Our Ref: BR/25/21/DOC

Town & Country Planning Act 1990 (as amended)
Town and Country Planning (Development Management Procedure) (England) Order 2015
Approval of details reserved by condition imposed under ref BR/257/19/PL relating to Condition No 4 -
balcony railings (height, finish, manufacturer/model name)
The Royal Hotel The Esplanade Bognor Regis PO21 1SZ

Arun District Council have decided to **APPROVE details reserved by this condition**

GA-APG-001-004-002

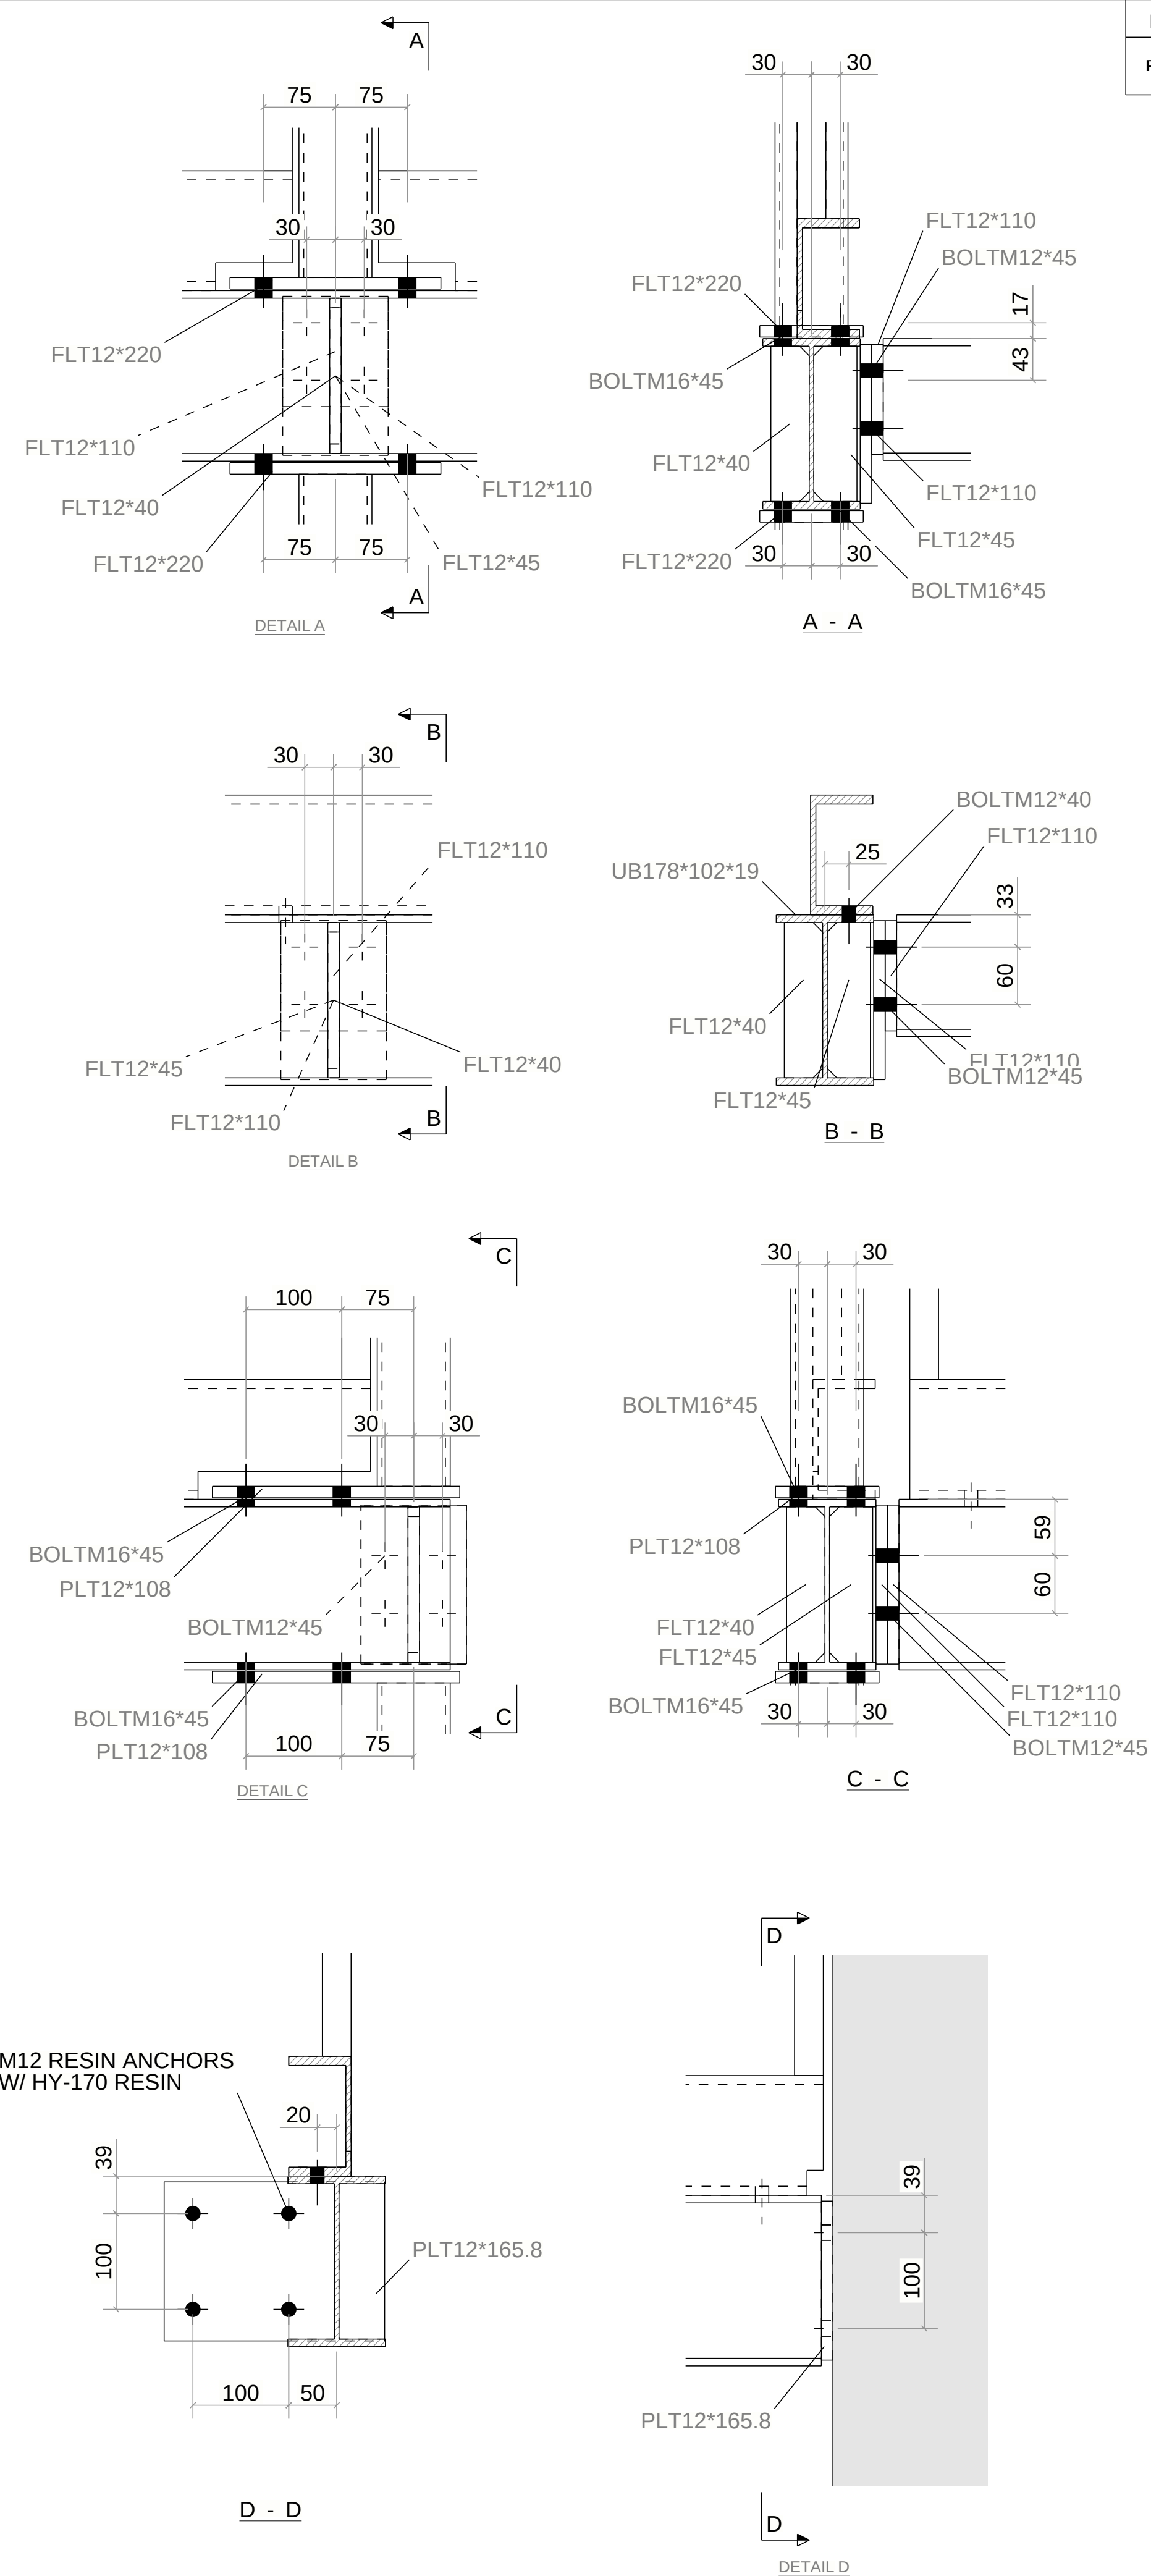
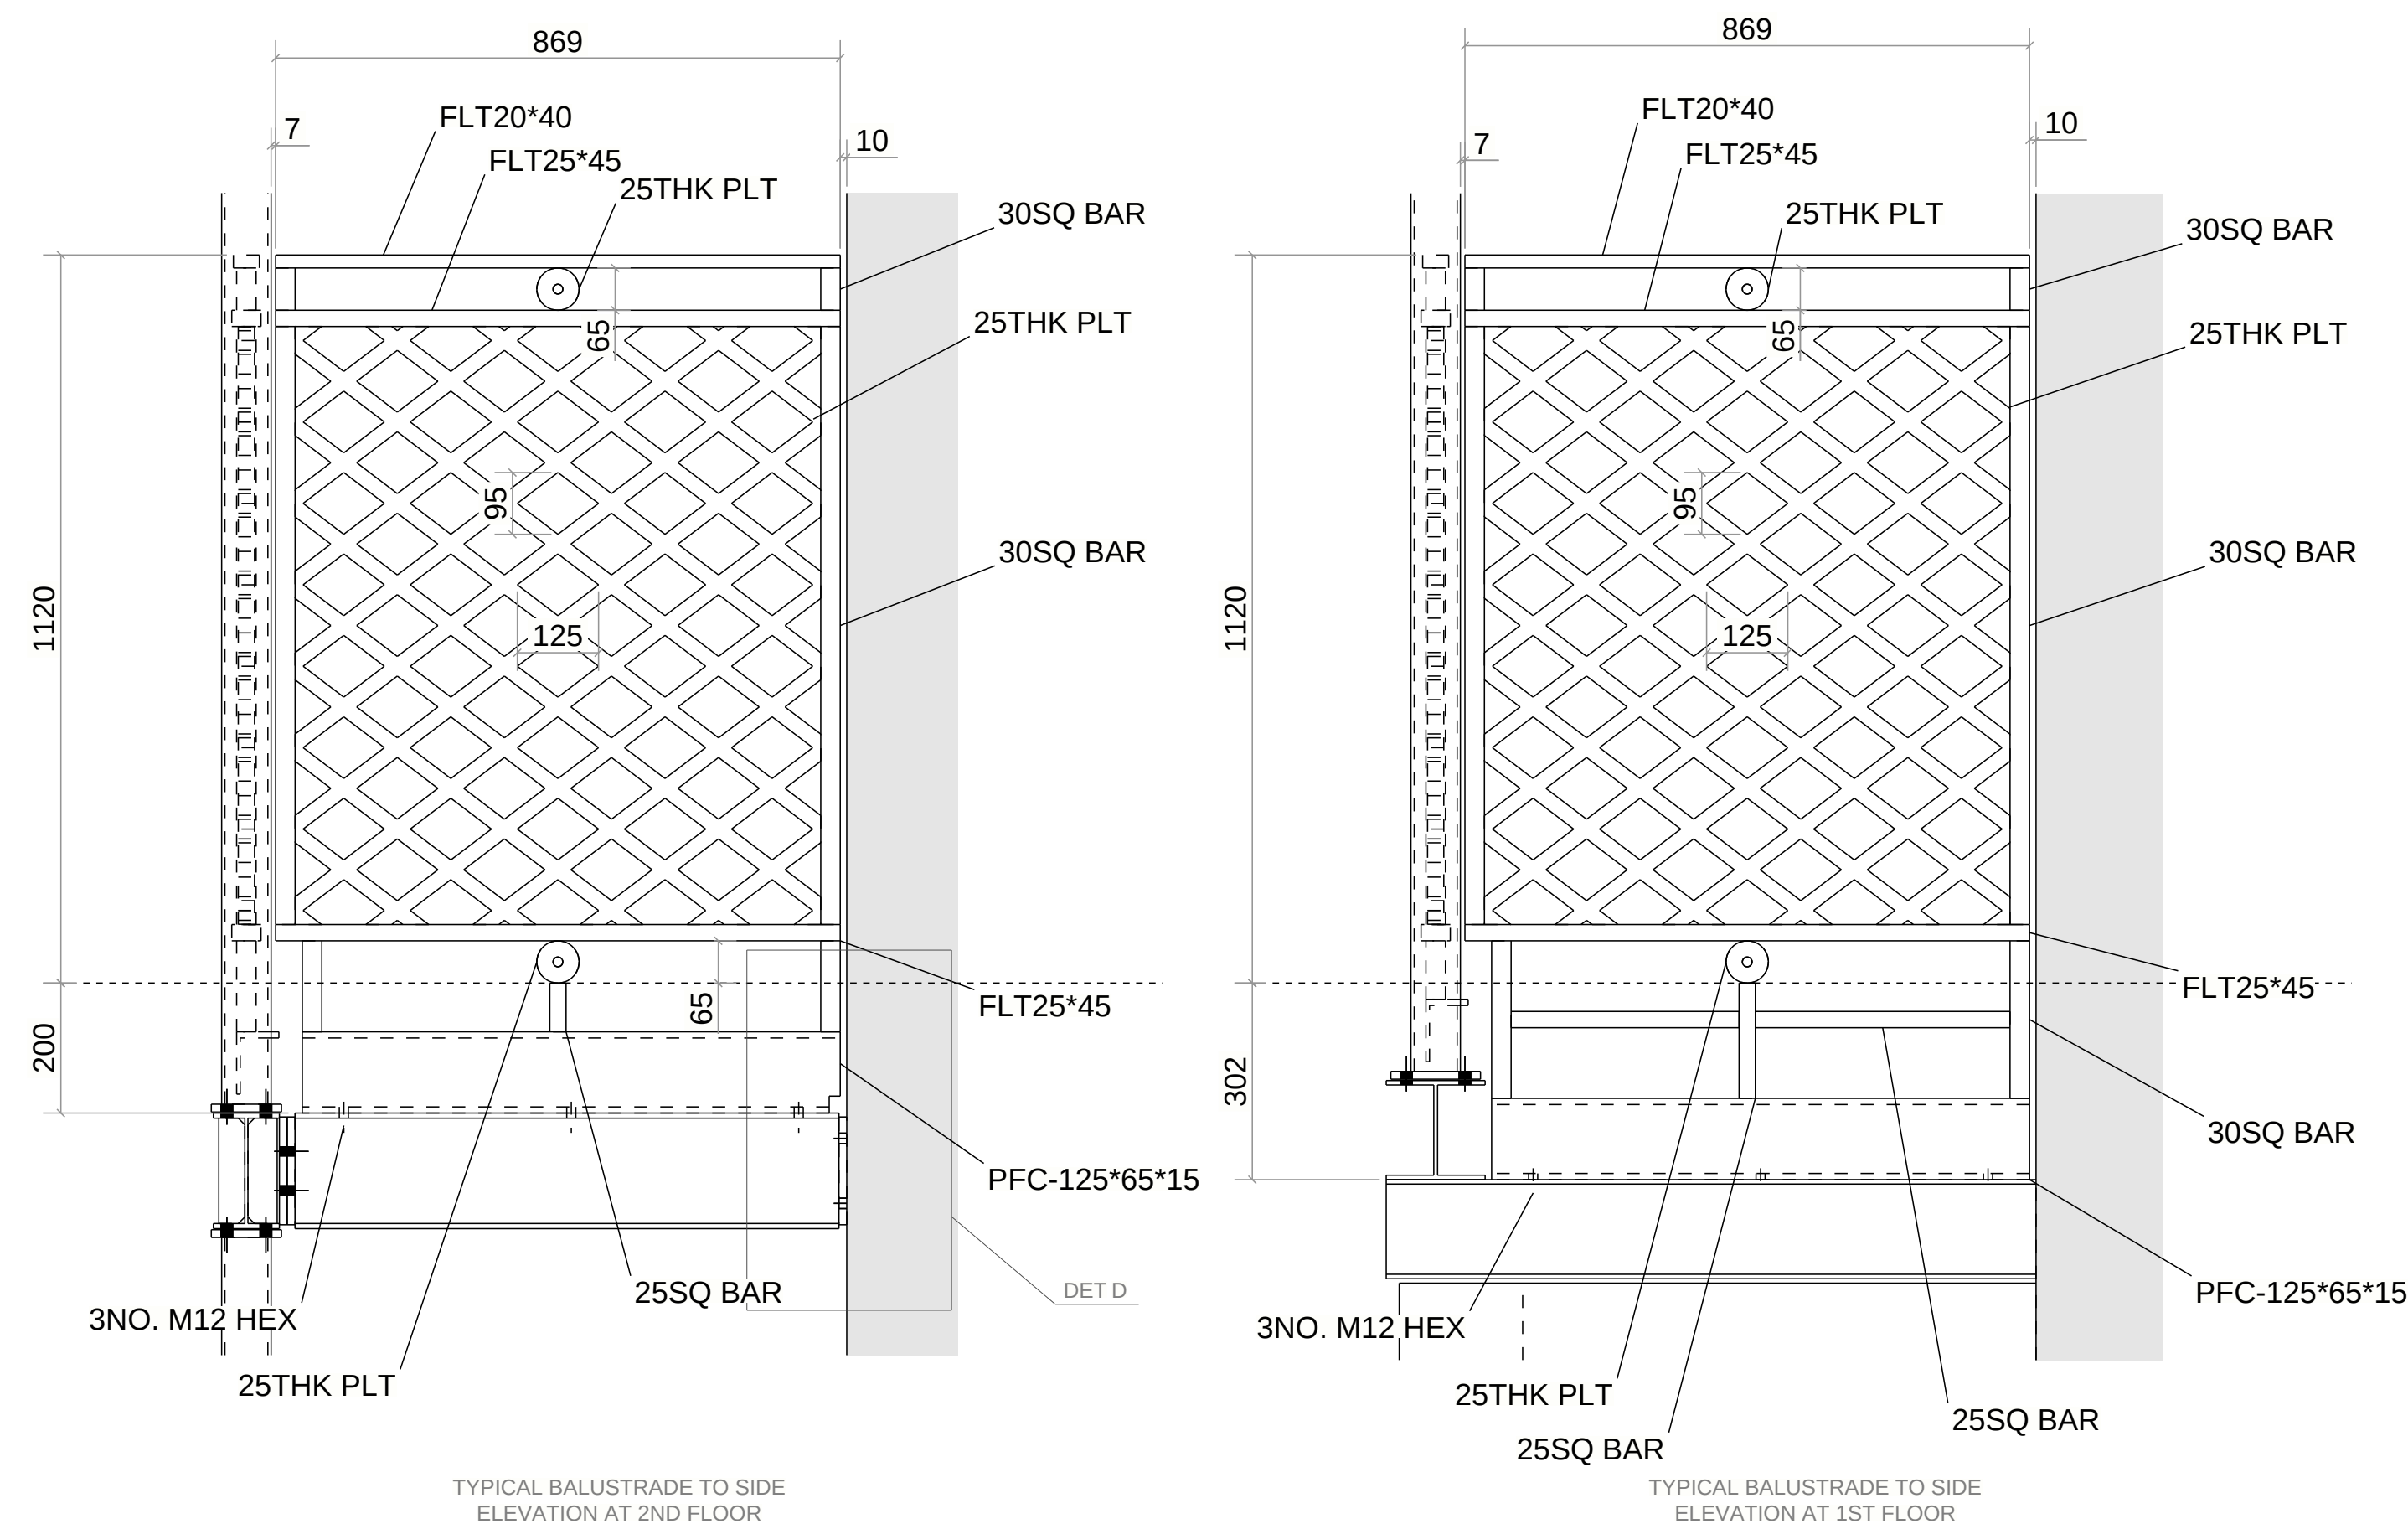
Type 4 - New Metalwork, proposed height 1120mm, black painted, Bespoke railing produced by Alpine Group, drawing "S4068-GA-001" and "S4068-GA- 002".
